From: Laura Gibbons <Laura.Gibbons@arun.gov.uk>
Sent: 19 September 2019 09:47
To: Planning.Responses <Planning.Responses@arun.gov.uk>
Subject: RE: Planning Consultation on BN/83/19/DOC

Engineers Comments Regarding Condition 4- surface water drainage:

APPLICATION NO: BN/83/19/DOC

Description of Works: Approval of details reserved by condition imposed under EG/50/16/PL relating to condition 4-details of surface water drainage scheme.

SOAKAWAY USING SDS GEOLIGHT 400 GEOMODULAR UNITS

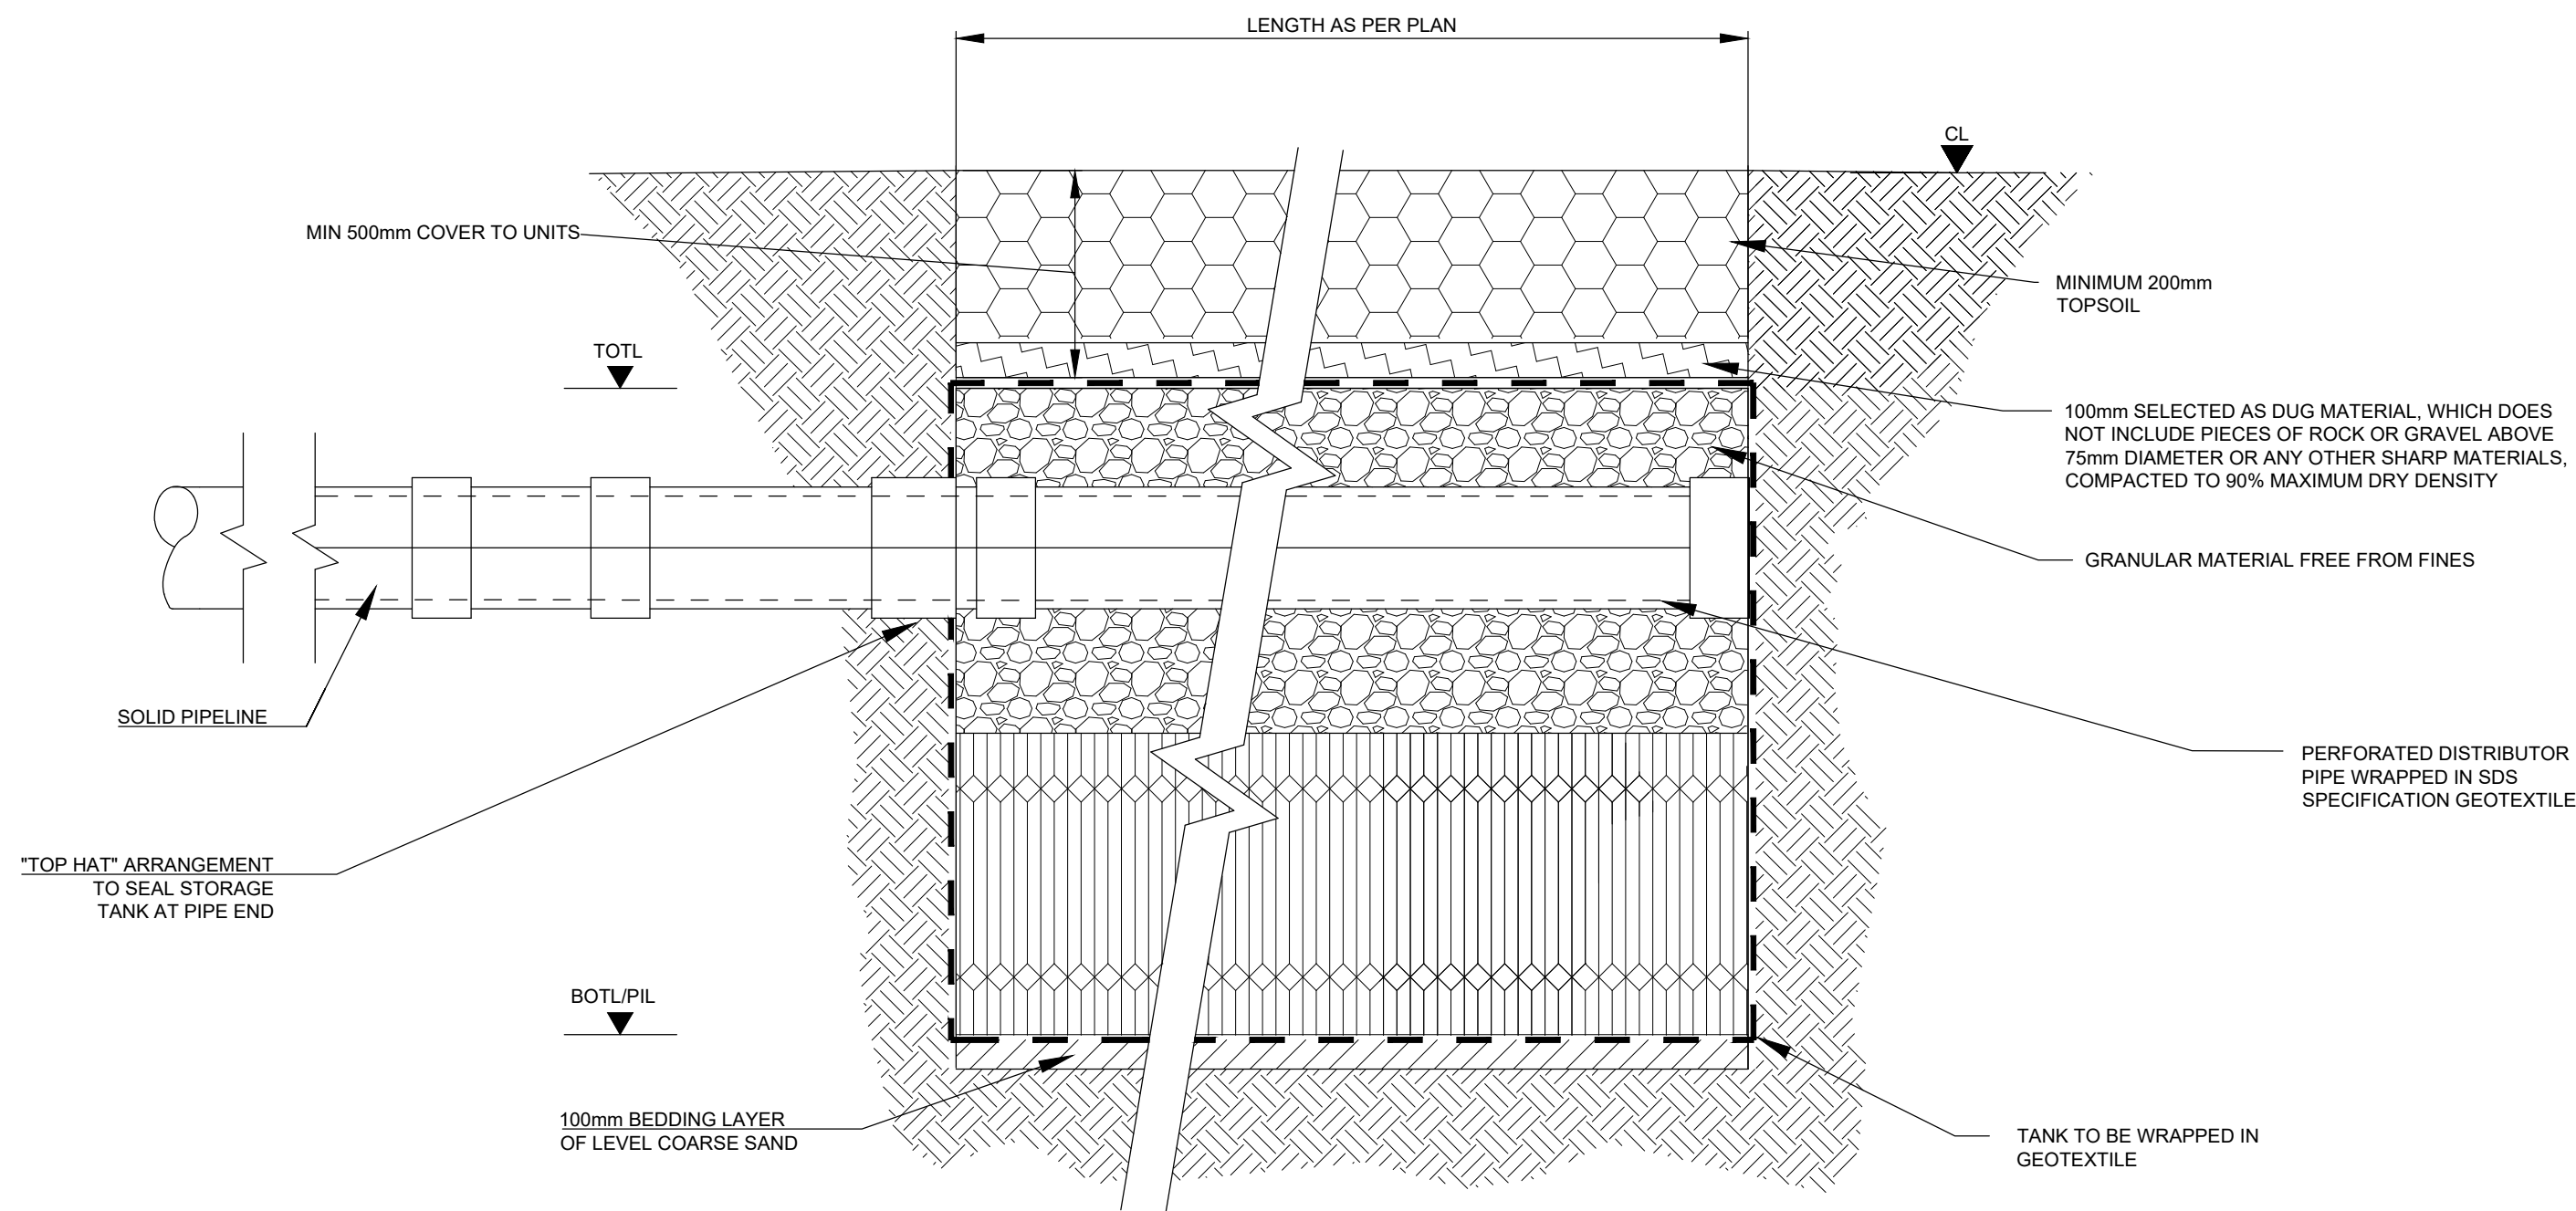
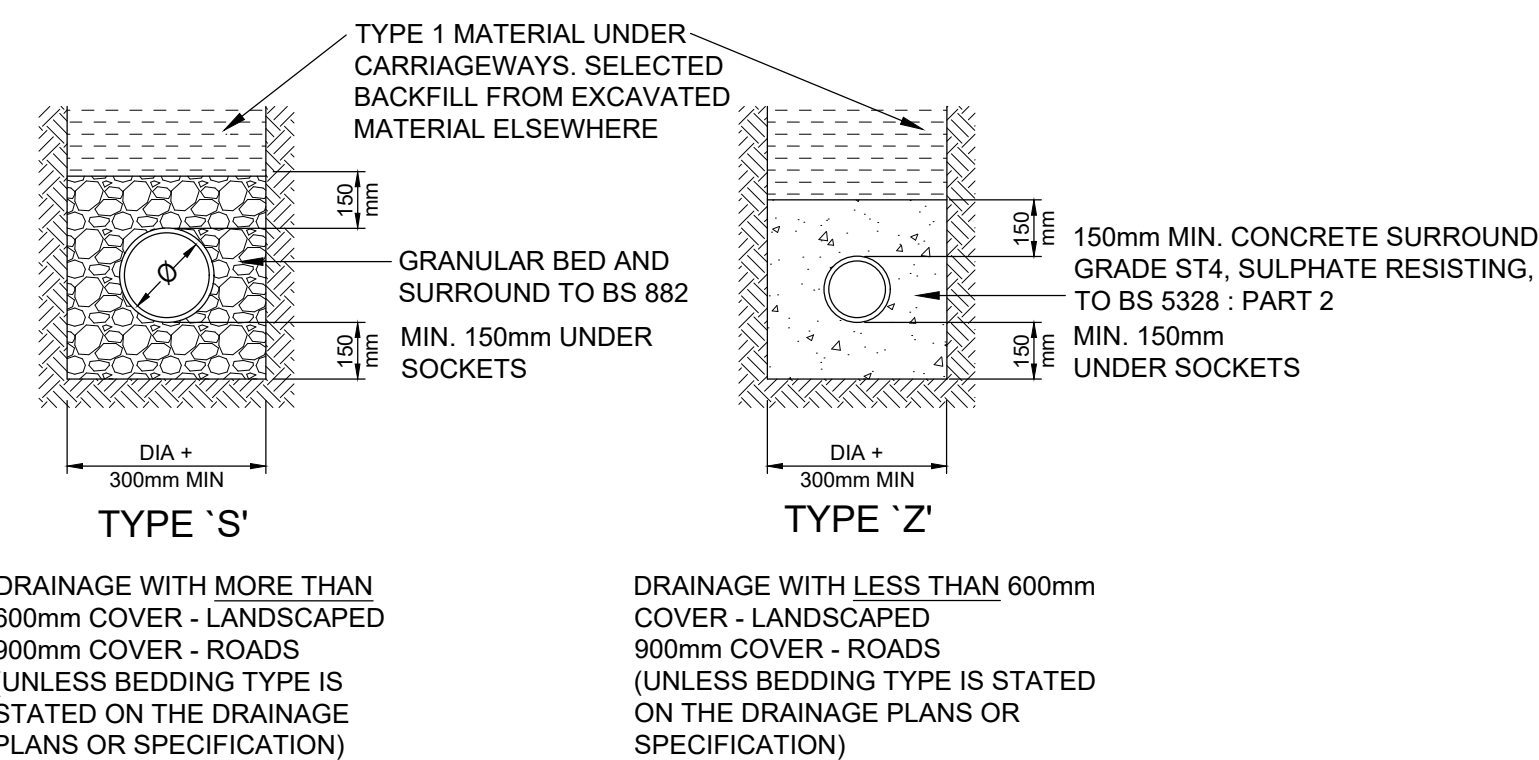
With the limited groundwater monitoring undertaken we would be keen to see soakaways kept shallower. The soakaways as currently proposed are deeper than the depth of infiltration testing.
